Subject: Rezoning Petition Review

Rezoning Petition #: 22-087

Proposed Zoning: UR-2 (CD)

Location of Property: Approximately 10.95 acres located on the east side of Mallard Creek Rd, north of Governor Hunt Rd and west of David Taylor Dr.

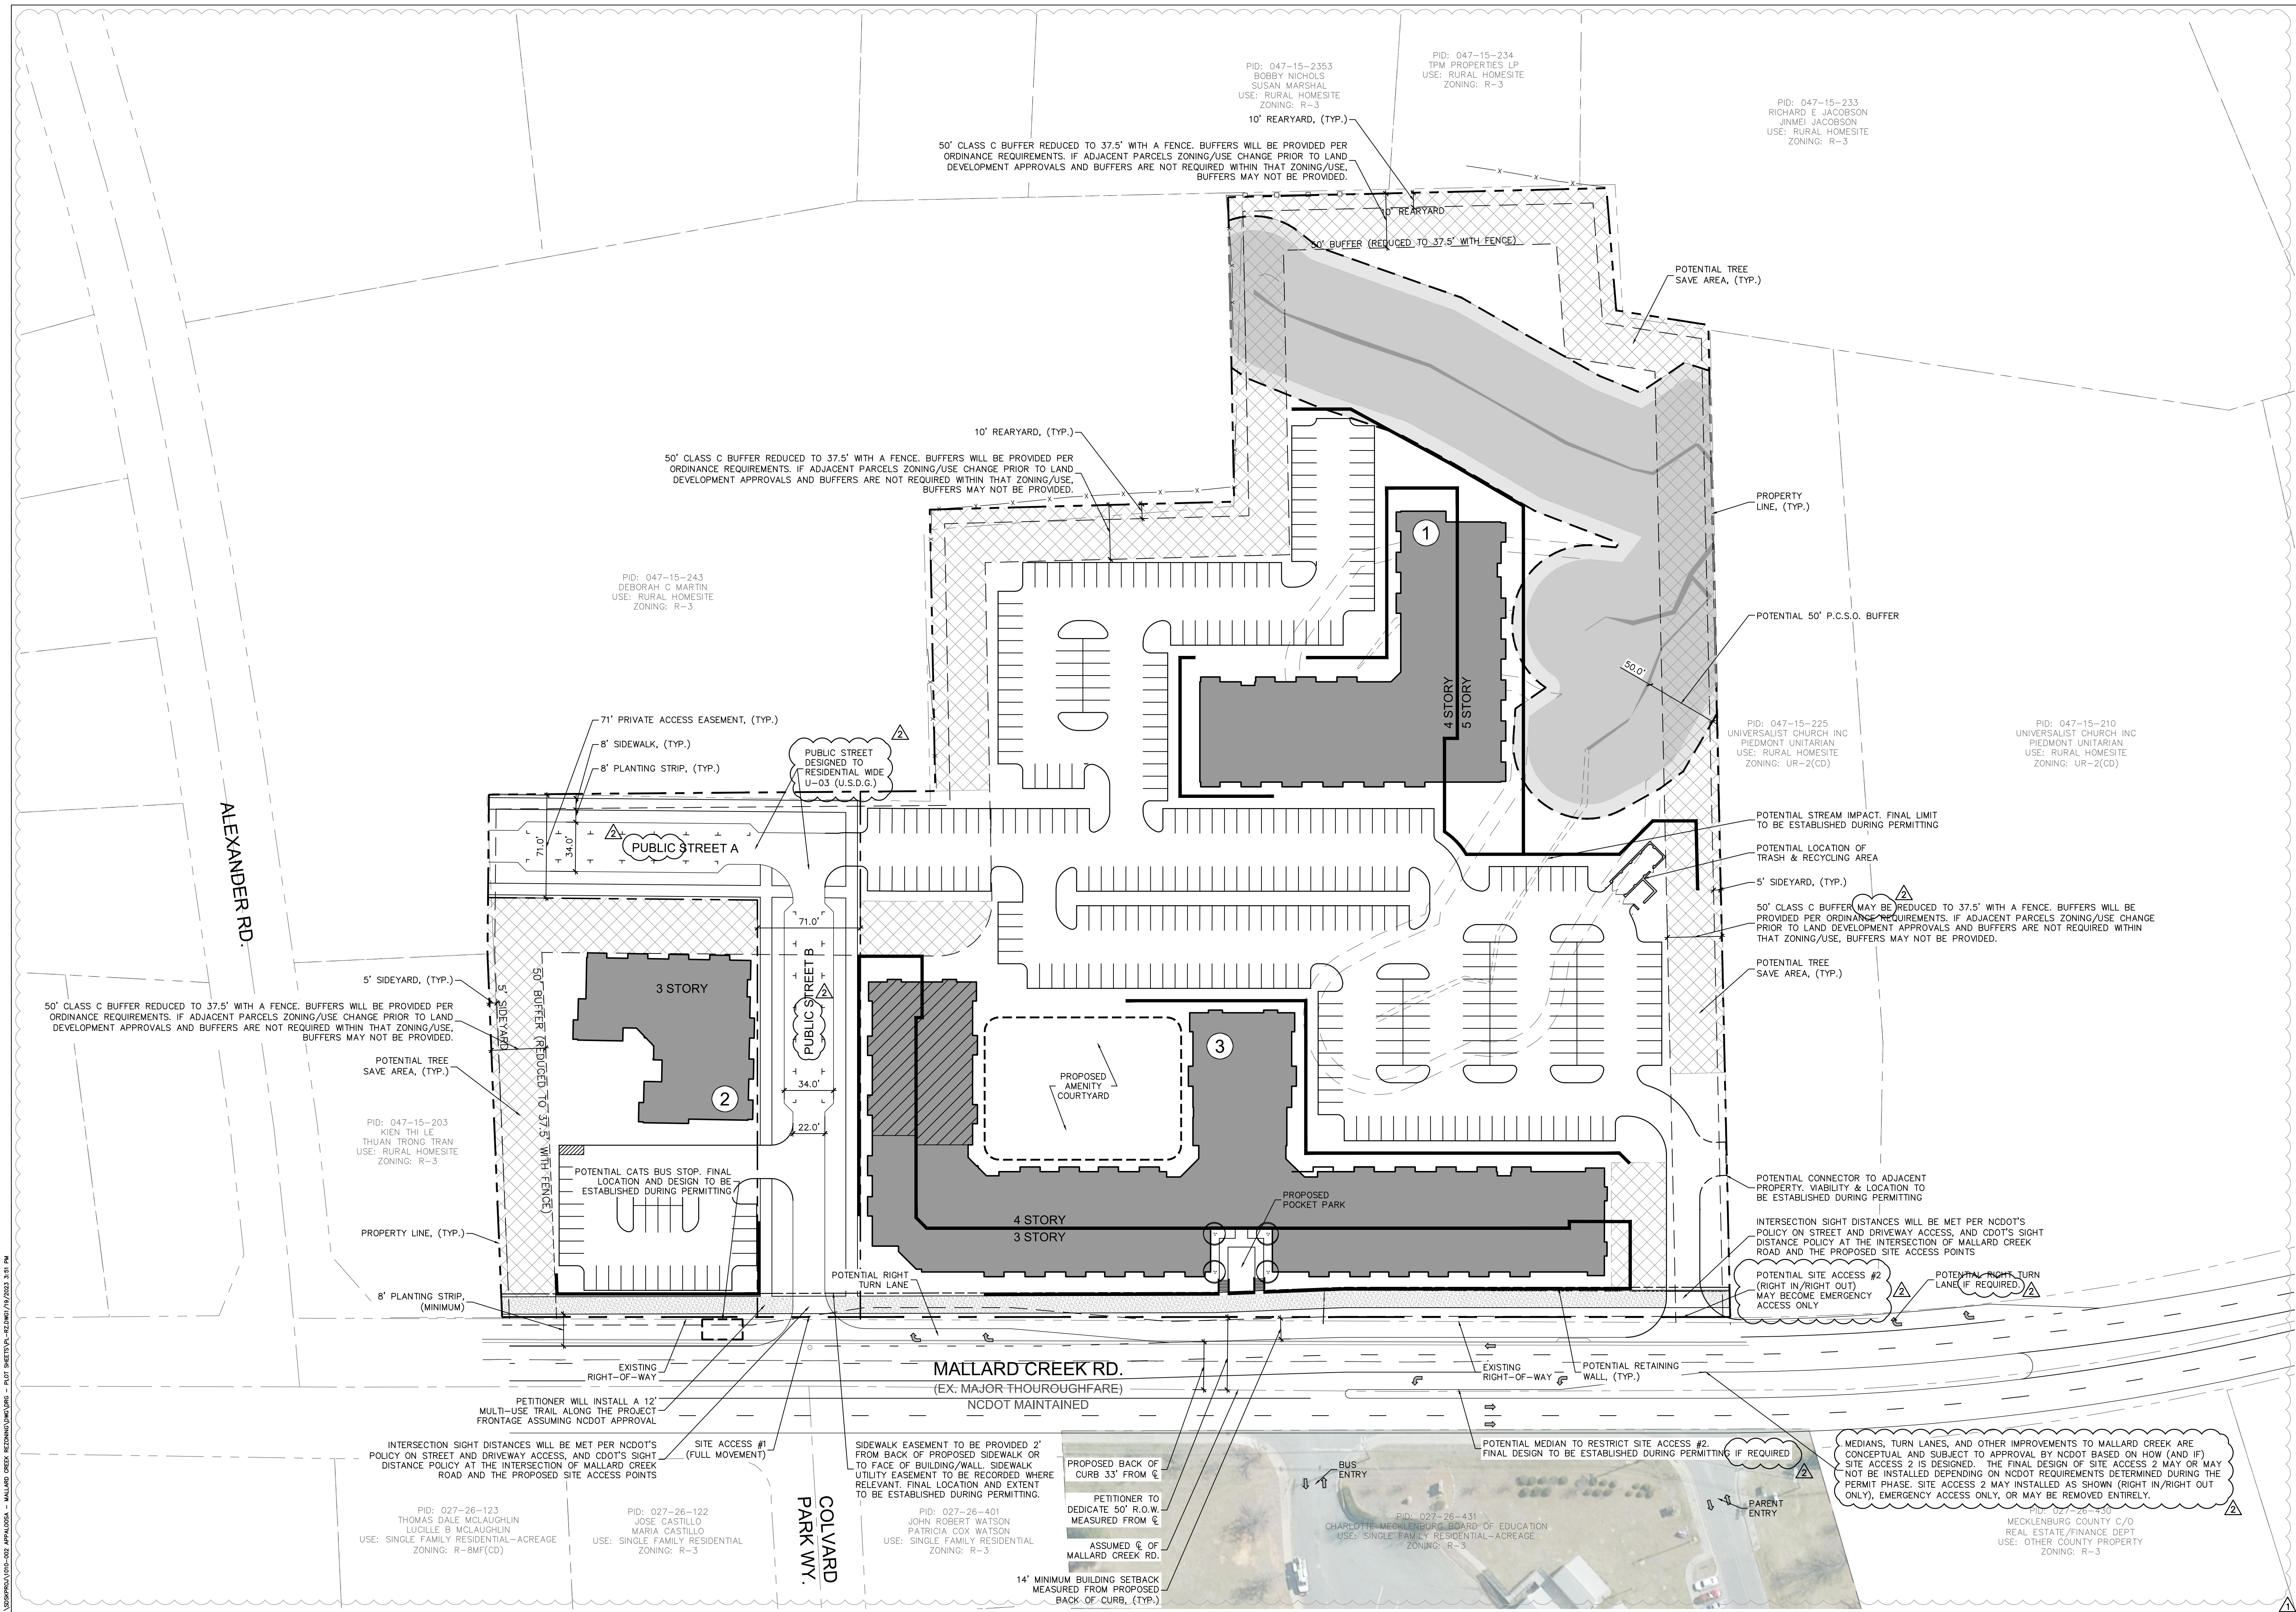
Please label *Potential 50-ft Undisturbed PCSO Buffer* on the site plan. Any increase of impervious area within such buffers may not be allowed and is not approved with the rezoning process. Stream Delineation Reports are subject to review and approval by Charlotte Storm Water Services. Please include the following note under Environmental Features: *“Development within any SWIM/PCSO Buffer shall be coordinated with and subject to approval by Charlotte-Mecklenburg Storm Water Services and mitigated if required by City ordinance. Petitioner acknowledges intermittent/perennial stream delineation reports are subject to review and approval upon submission of development plans for permitting and are not approved with rezoning decisions.”*

This property drains to Mallard Creek, which is an impaired/degraded stream, and may contribute to downstream flooding. This project has the opportunity to mitigate future impacts to this stream, therefore, Storm Water recommends placing the following notes on the plan:

(I) Storm Water Quality Treatment

For defined watersheds greater than 10% built-upon area (BUA), construct water quality stormwater control measures (SCMs) designed for the runoff generated from the first 1-inch of rainfall for all new and redeveloped BUA associated with the project. SCMs must be designed and constructed in accordance with the Charlotte-Mecklenburg BMP Design Manual.

(II) Volume and Peak Control

For defined watersheds greater than 10% built-upon area, control the entire volume for the 1-year, 24-hour storm for all new and redeveloped BUA associated with the project. Runoff volume drawdown time shall be in accordance with the Charlotte-Mecklenburg BMP Design Manual.

For commercial projects with greater than 10% BUA, control the peak to not exceed the predevelopment runoff rates for the 10-yr, 6-hr storm and perform a downstream flood analysis to determine whether

additional peak control is needed and if so, for what level of storm frequency, or if a downstream analysis is not performed, control the peak for the 10-yr and 25-yr, 6-hour storms.

For residential projects with greater than 10% BUA, control the peak to not exceed the predevelopment runoff rates for the 10-year and 25-year, 6-hour storms or perform a downstream analysis to determine whether peak control is needed, and if so, for what level of storm frequency.
